Date: 20-Oct-2023
Our Ref: 2022/92957

**Discharge of conditions 3 (external facing materials), 4 (roofing materials), 5 (boundary treatment), 7 (amended elevations and sections), 8 (demolition), 11 (BEMP), 13 (noise), 17 (electric vehicle charging), 18 (CEMP), 19 (landscape) and 29 (waste collection) of previous permission 2021/94664 for demolition of existing building and development of the former dyeworks comprising 9 apartments, 4 bungalows and 2 maisonettes (within a Conservation Area)
Former Hoyle Ing Dyeworks, Hoyle Ing, Linthwaite, Huddersfield, HD7 5QS
Application Number: 2022/92957**

LAND OFF MANCHESTER ROAD, LINTHWAITE
PROPOSED EVCP PLAN

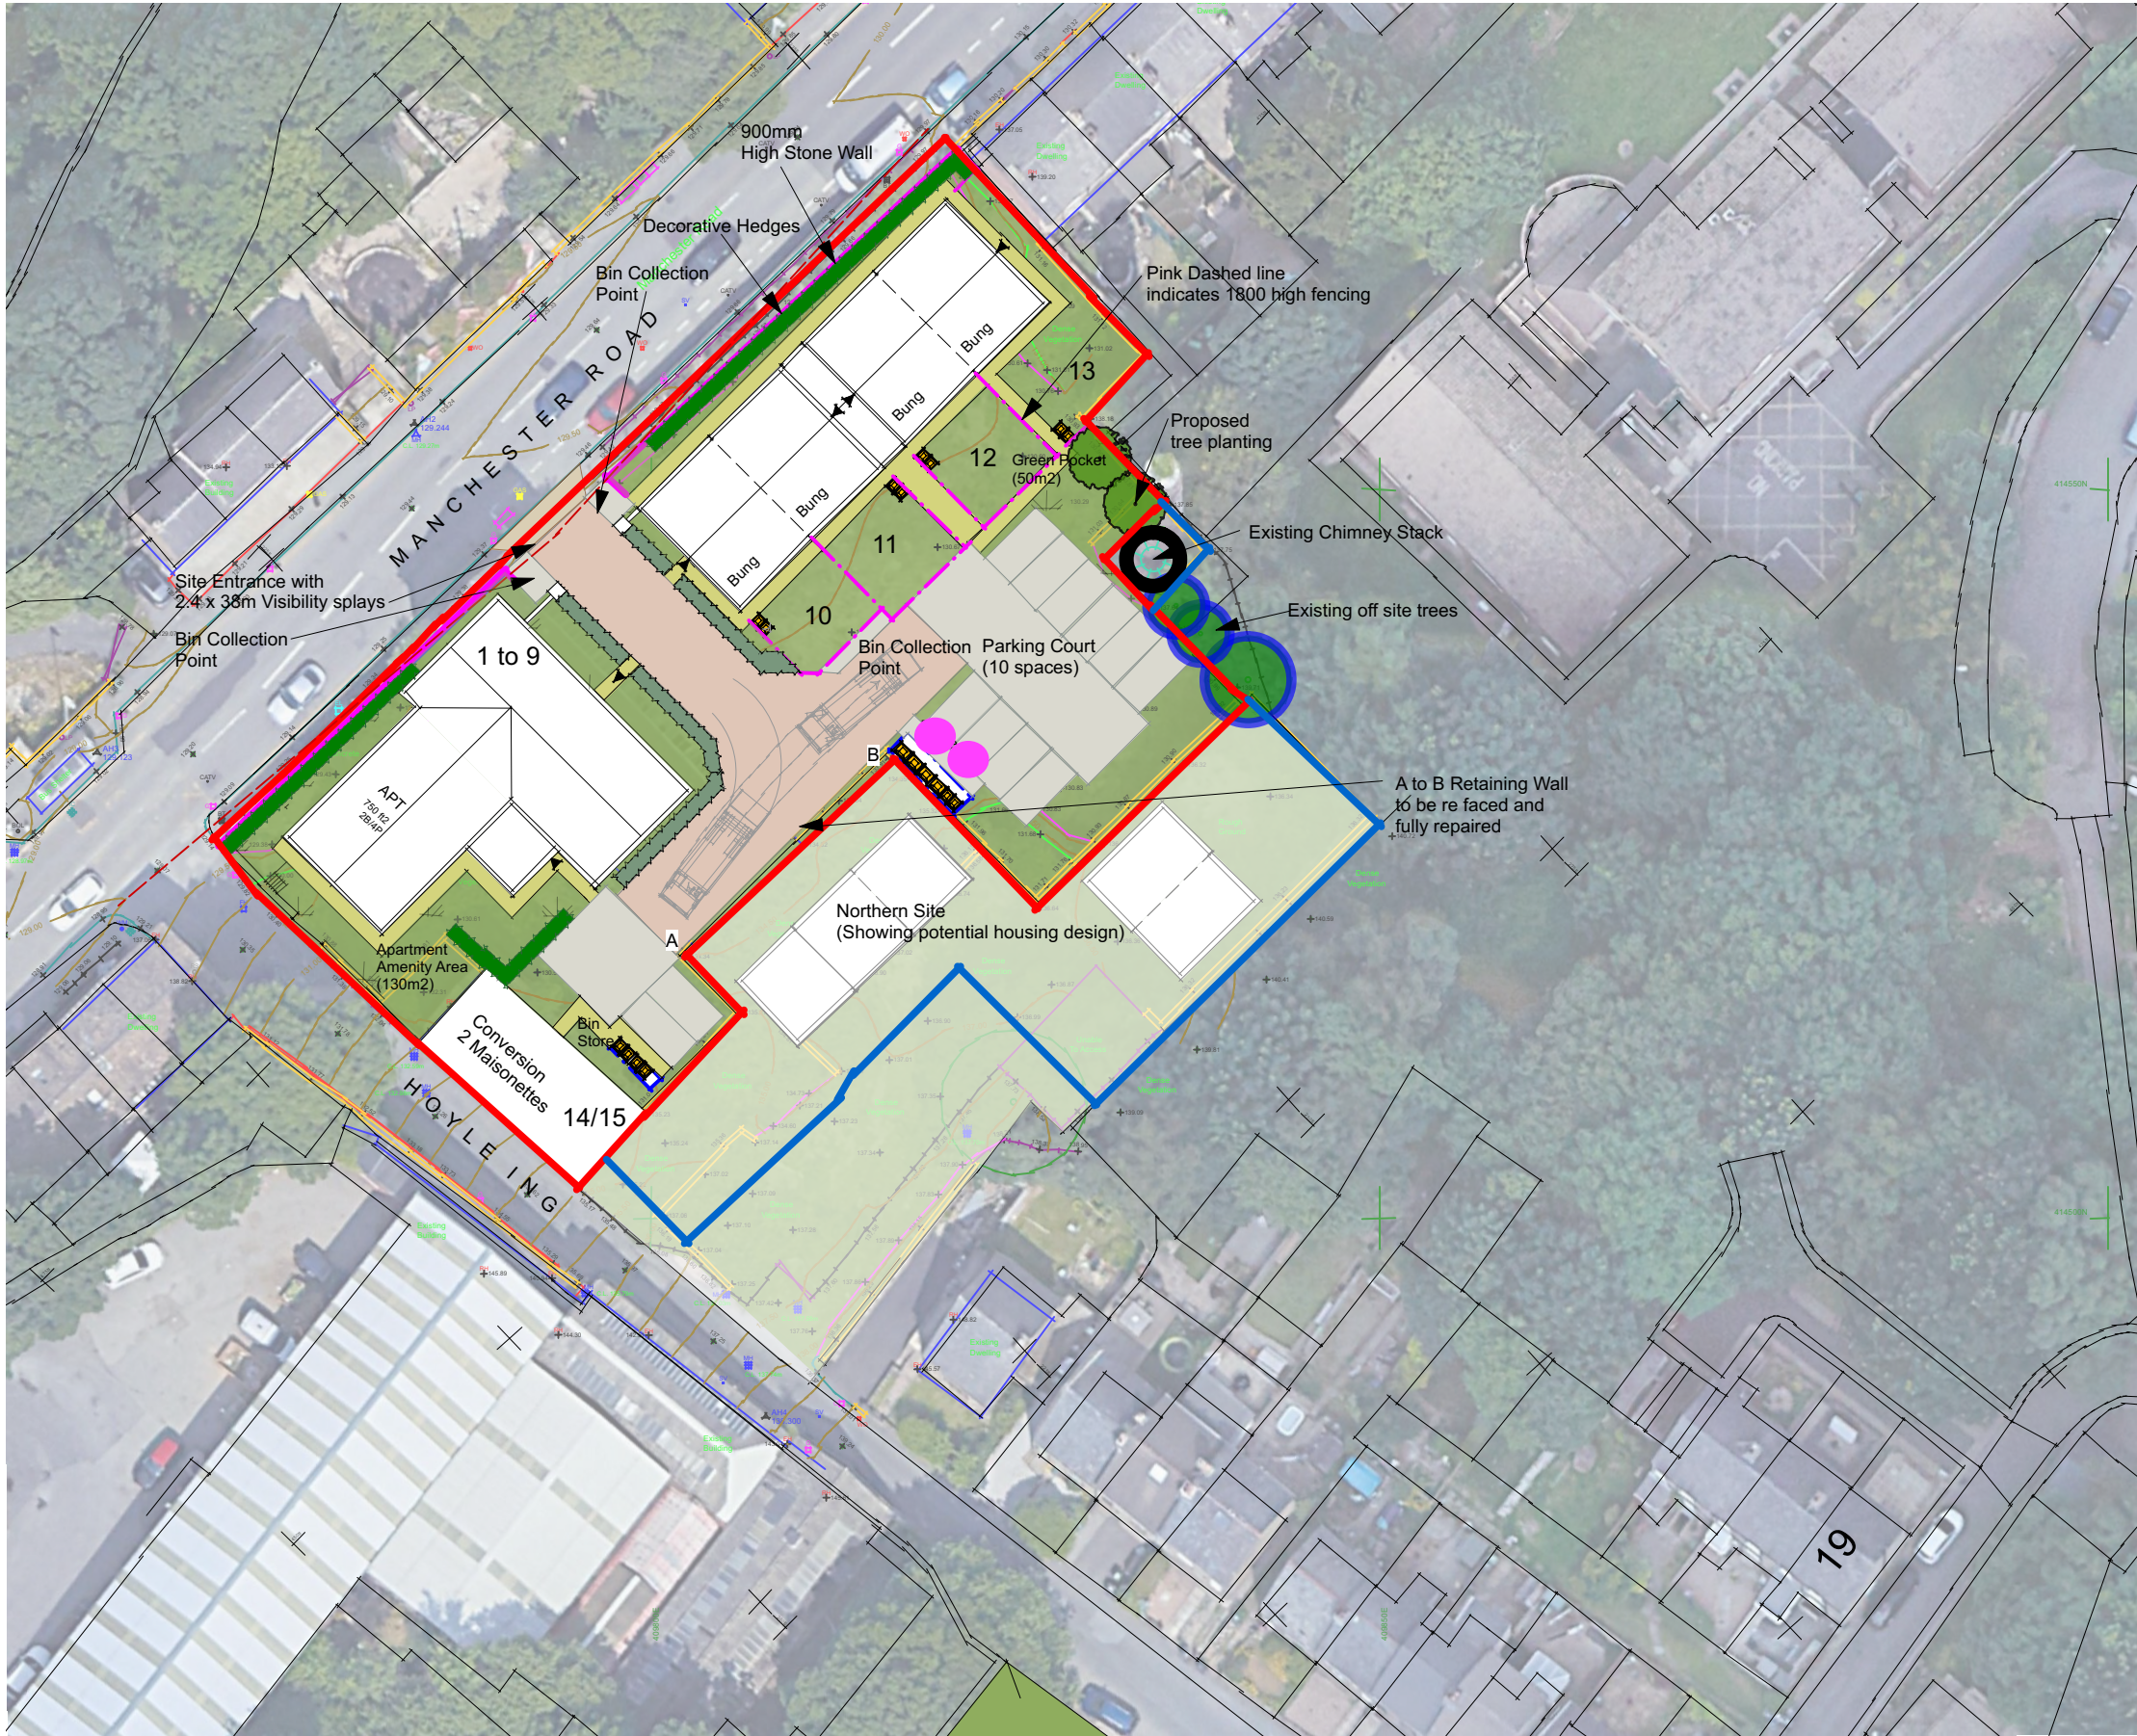
The plan illustrates the location of four electric vehicle charging points within the site boundary. These details are considered acceptable for the purpose of condition 17, and are hereby approved.

Please be reminded of the further requirement of condition 17, which states that buildings and parking spaces that are to be provided with charging points shall not be brought into use until the charging points are installed and operational. Condition 17 also requires the charging points to be retained thereafter.

Figure 7: Internal layout of apartments

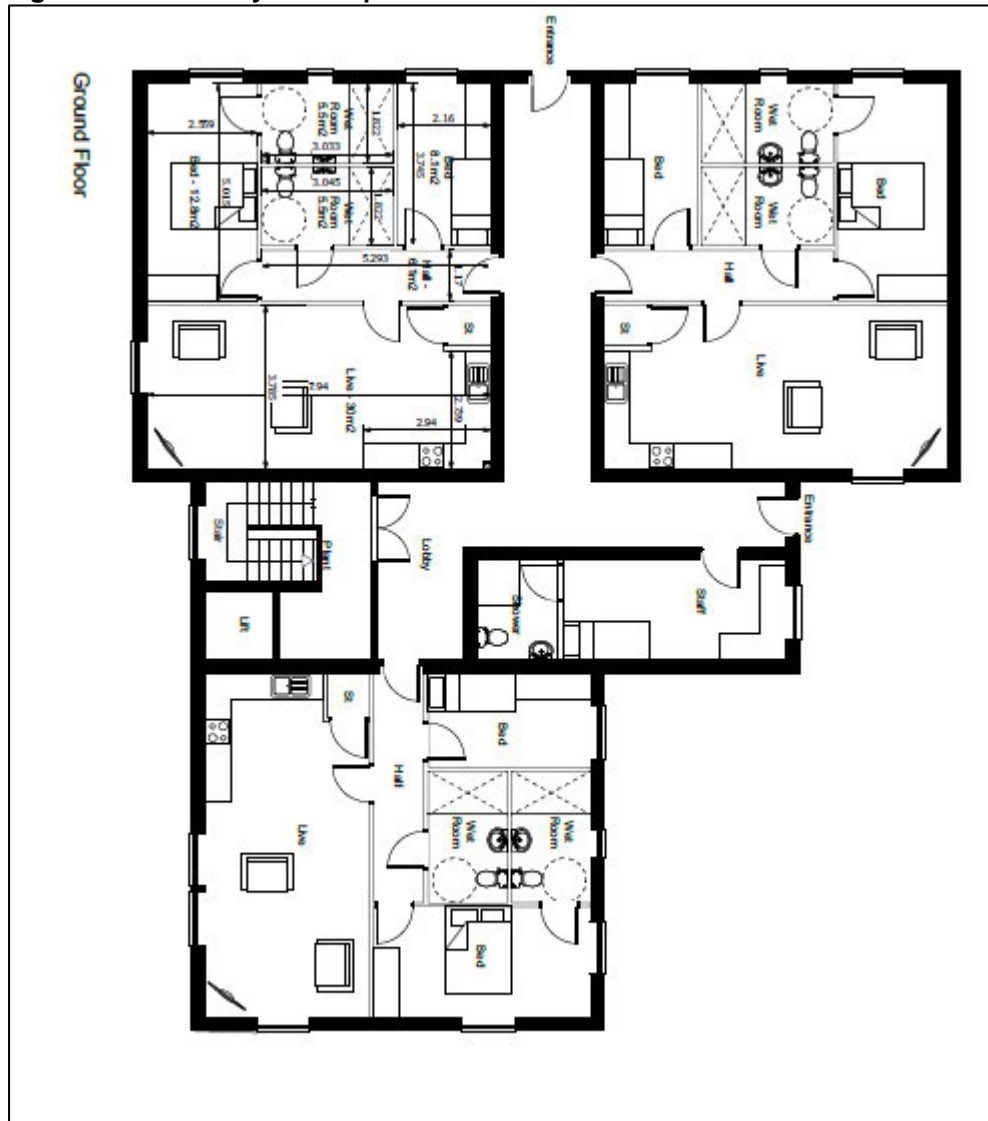
Figure 7 shows the internal layout of the apartments, figure 8 shows the internal layout of the bungalows and figure 9 shows the internal layout of the maisonettes. Based upon distance attenuation along with a 3dB correction for reflection, figure 10 specifies the required glazing for the apartments and figure 11 specifies the required glazing for the maisonettes. Table 4 indicates that with windows closed, the internal requirements of BS8233 would be met for all parts of the development. However, in order to achieve the BS 8233 guideline values and prevent disturbance, particularly sleep disturbance at night, the assessment shows that it will be necessary to keep habitable room windows closed. Para 4.22 states an alternative means of providing both background and cooling ventilation will be required in all habitable rooms which is typically achieved through the provision of whole-house passive input ventilation (PIV) or mechanical ventilation, either as whole-house systems (MVHR) or as through-wall solutions in individual rooms.

As such, the findings of this report are accepted, subject to the works recommended within the submitted Noise Assessment being installed and retained thereafter.

NOTE: Notwithstanding the above, it is recommended that the applicant be advised that the ventilation system must meet with the internal requirements of BS8233 along with any requirements of the Building Regulations.
